DRB Application No.: 02DRB-01895 (SBP)
Project Name: **RANCHO ENCANTADO SUR**
Agent: ~~Consensus Planning~~ *Bhannon*

Project # **1002384**
EPC Application No.: Z-95-94, Z-99-84, 01138-01744
Phone No.: *764-9801*

5. Project # 1002384

CONSENSUS PLANNING agent(s) for D. R. HORTON HOMES request(s) the above action(s) for all or a portion of Tract(s) 1 (to be known as **RANCHO ENCANTADO SUR**) COORS VILLAGE, zoned SU-3 special center zone, located on WESTERN TRAIL NW, between ATRISCO DR NW and COORS BLVD NW containing approximately 11 acre(s). [REF: 01138-01744, Z-95-94, Z-99-84, DRB-95-195, DRB-96-361] (F-11)

Conceptual Landscape Plan
 Rancho Encantado Sur

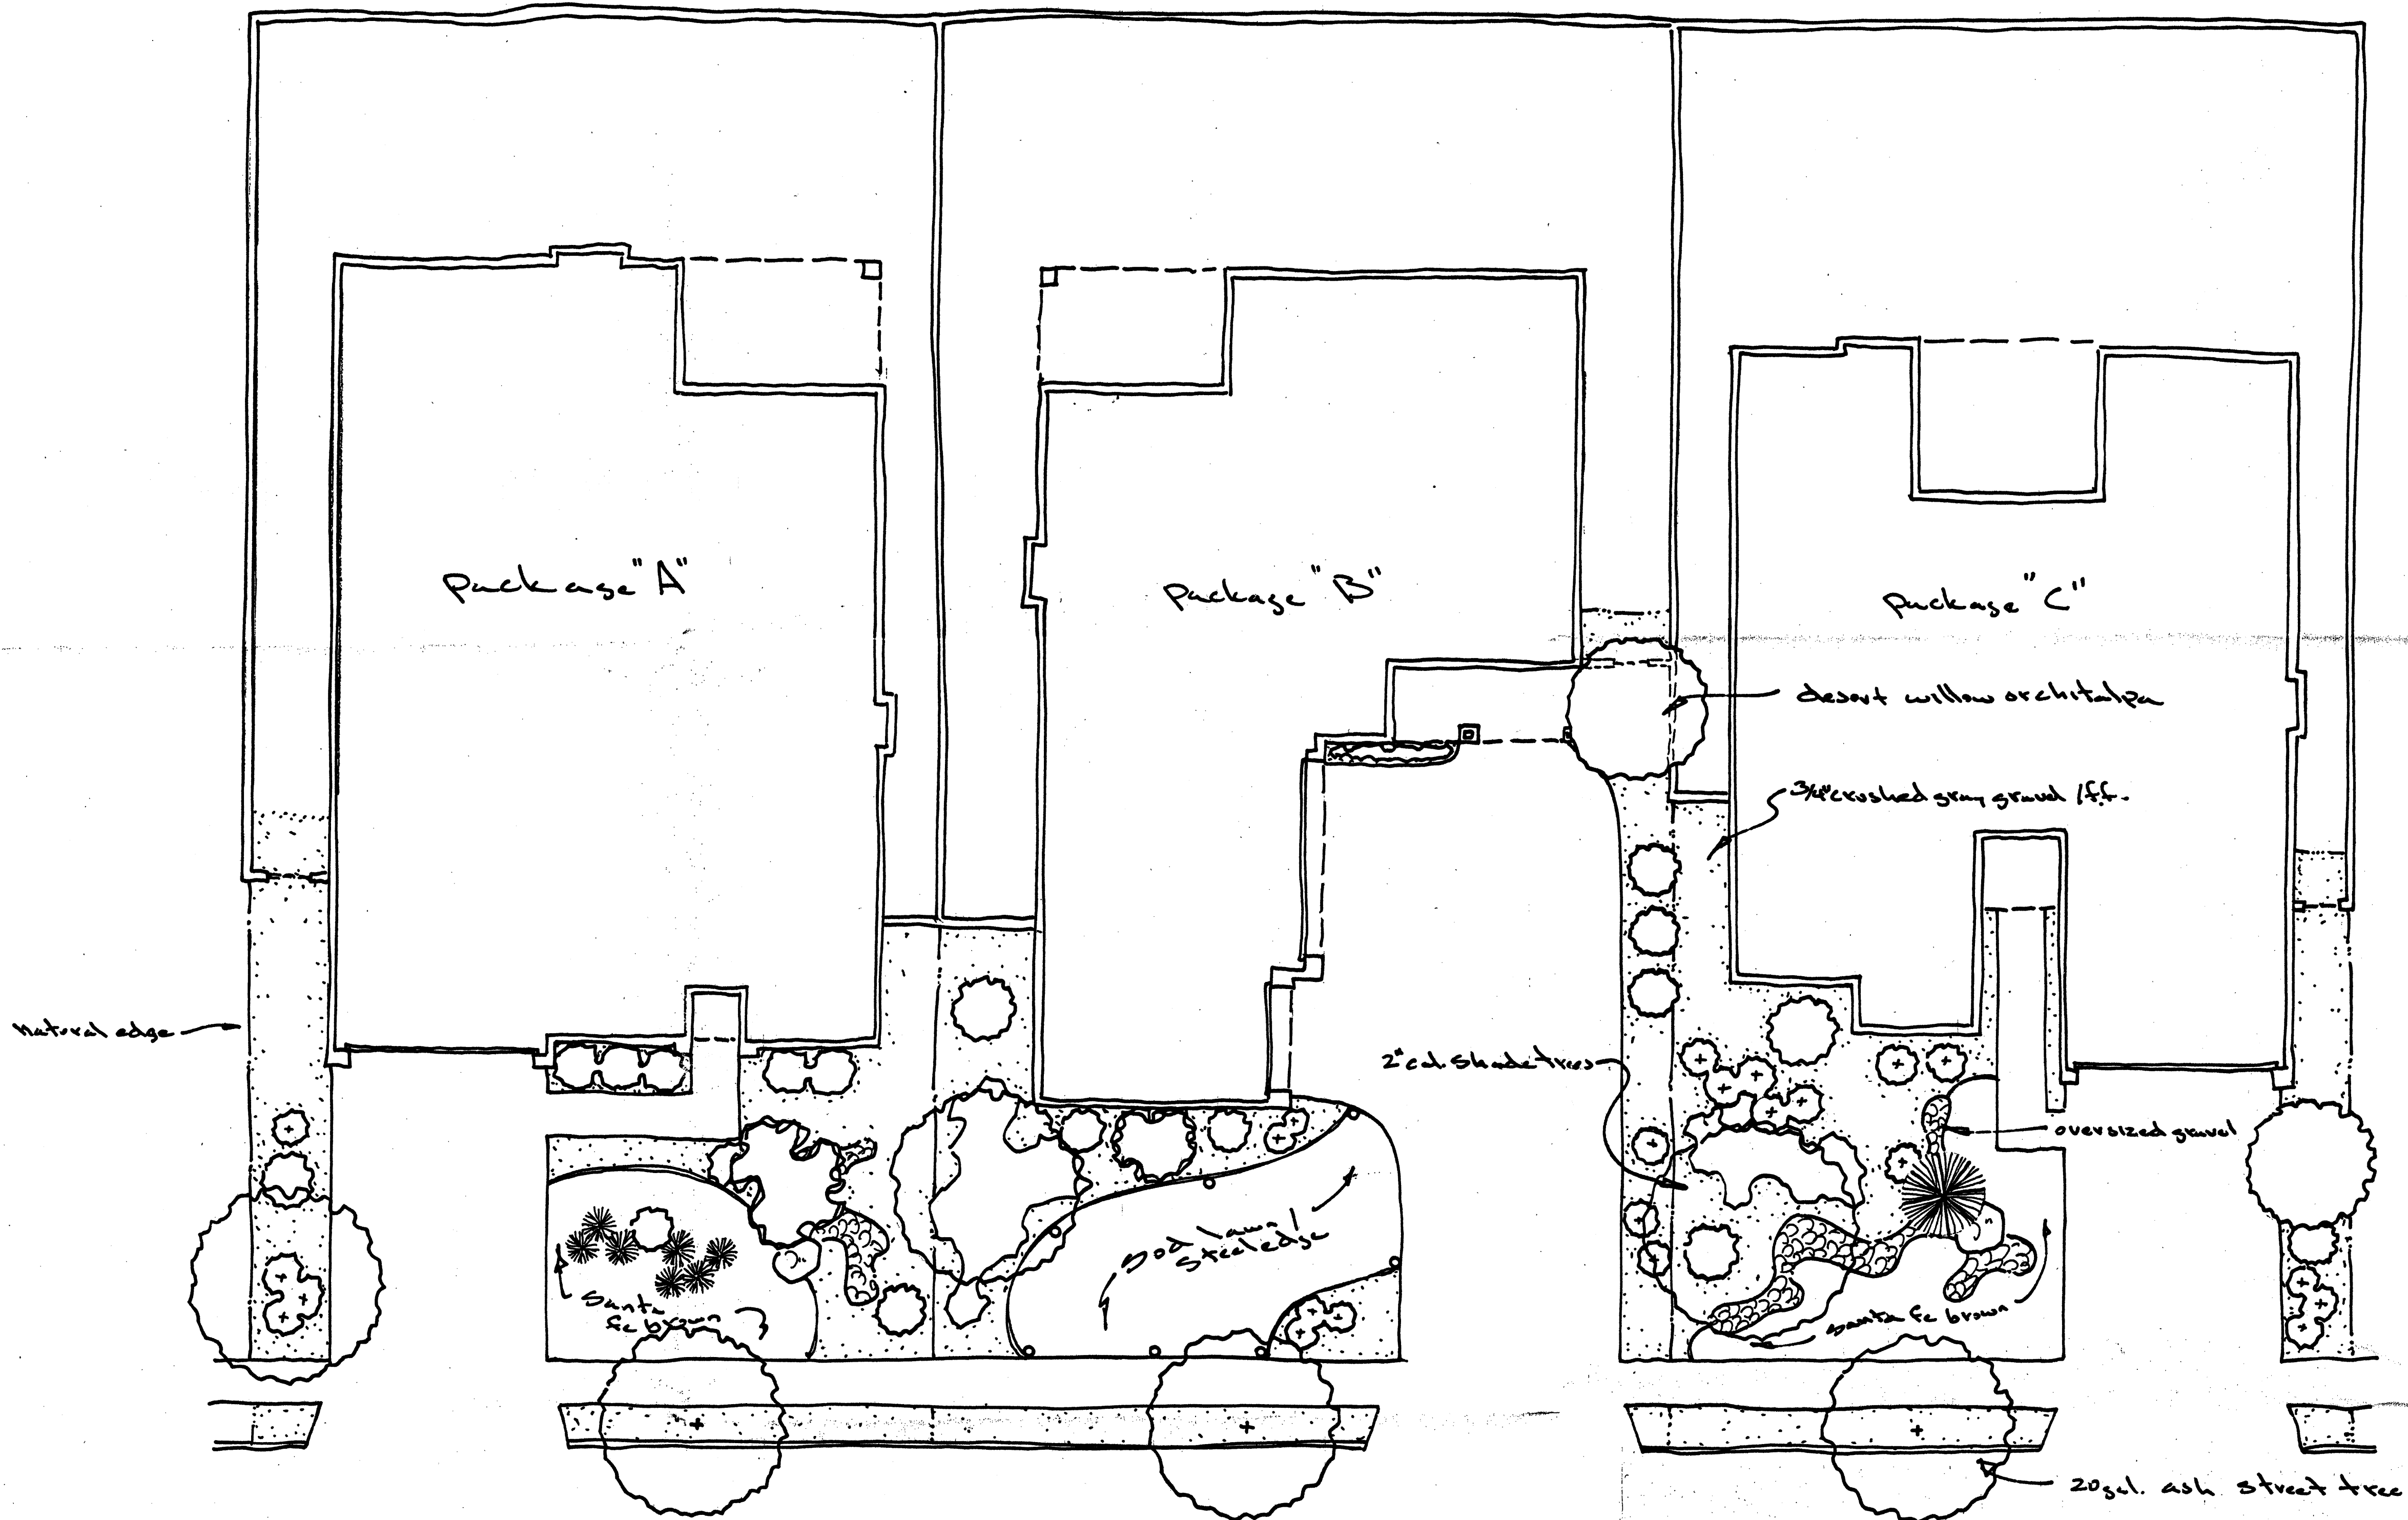
The landscape plan indicates honey locust, ash and Austrian pine as tree choices. Even though 20% high water usage plants are allowed, we strongly encourage 100% low & medium water use plants.

In addition, the use of high allergen junipers is strongly discouraged.

Add a typical lot landscape plan to the site plan as well.

Building Elevations
Rancho Encantado Norte

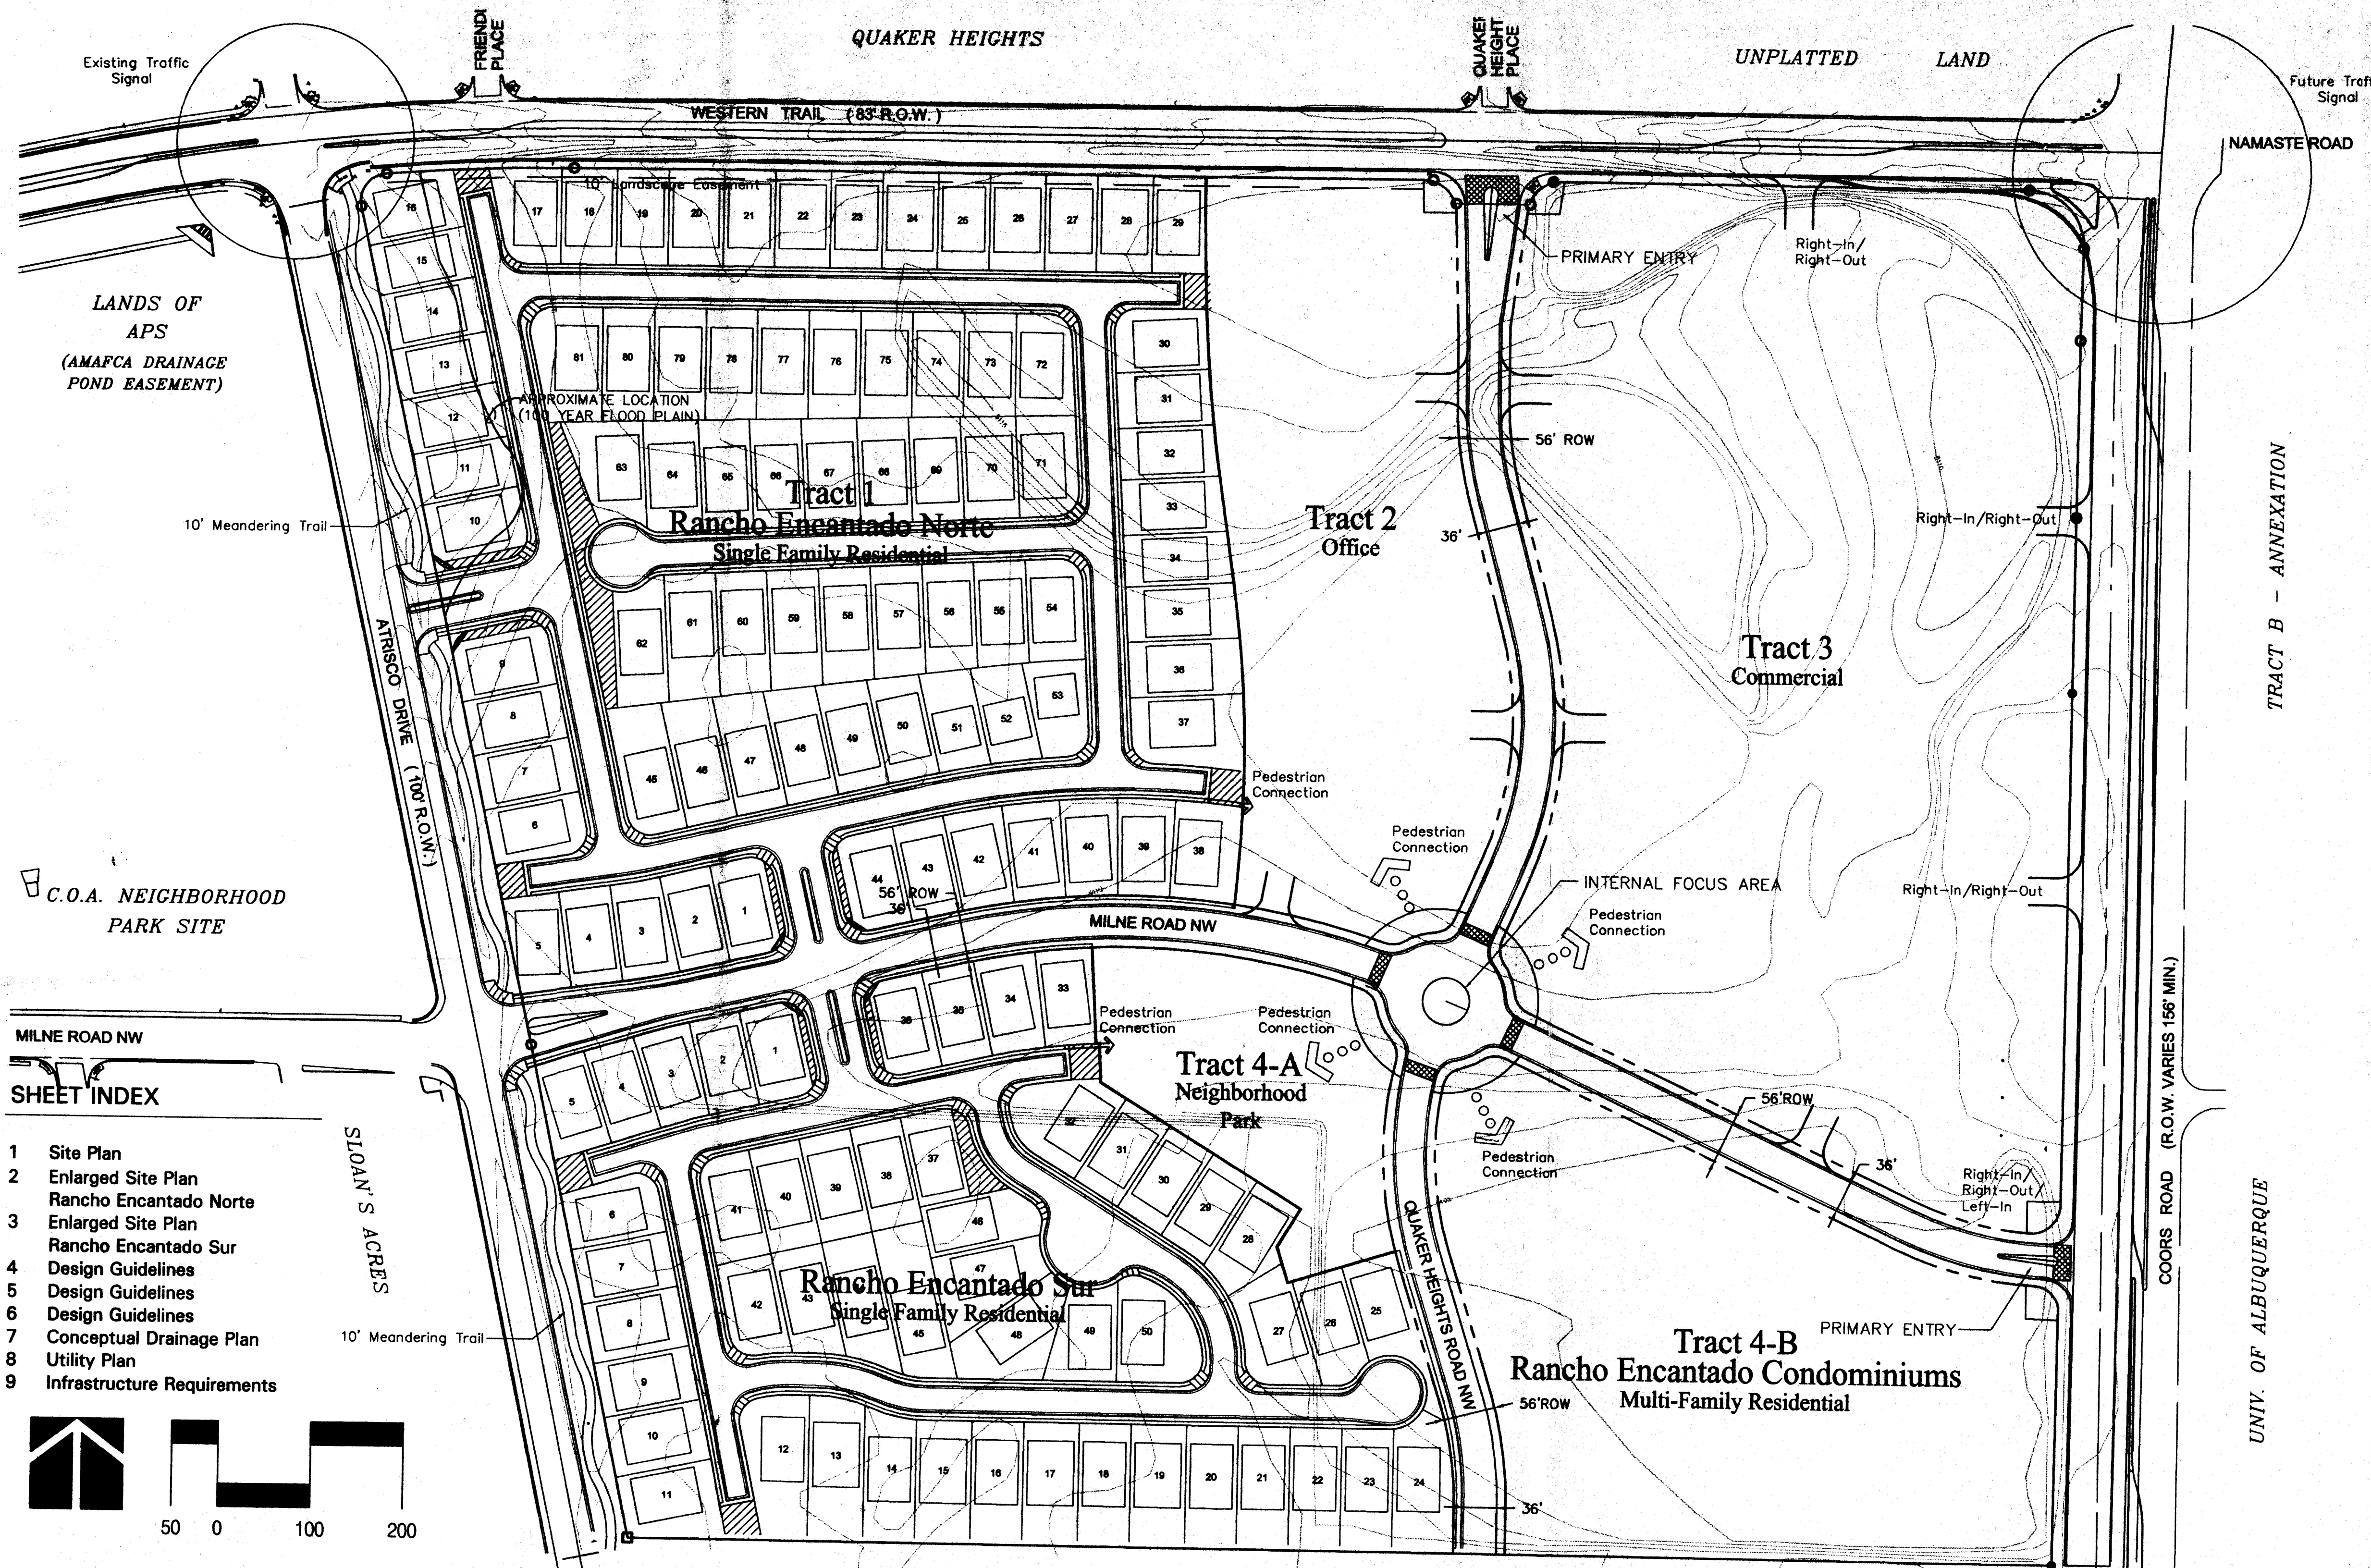
Indicate maximum height of 26 feet at midpoint of roof.

- 1) See Zoning's comments with reference to building heights shown on the elevations sheet.
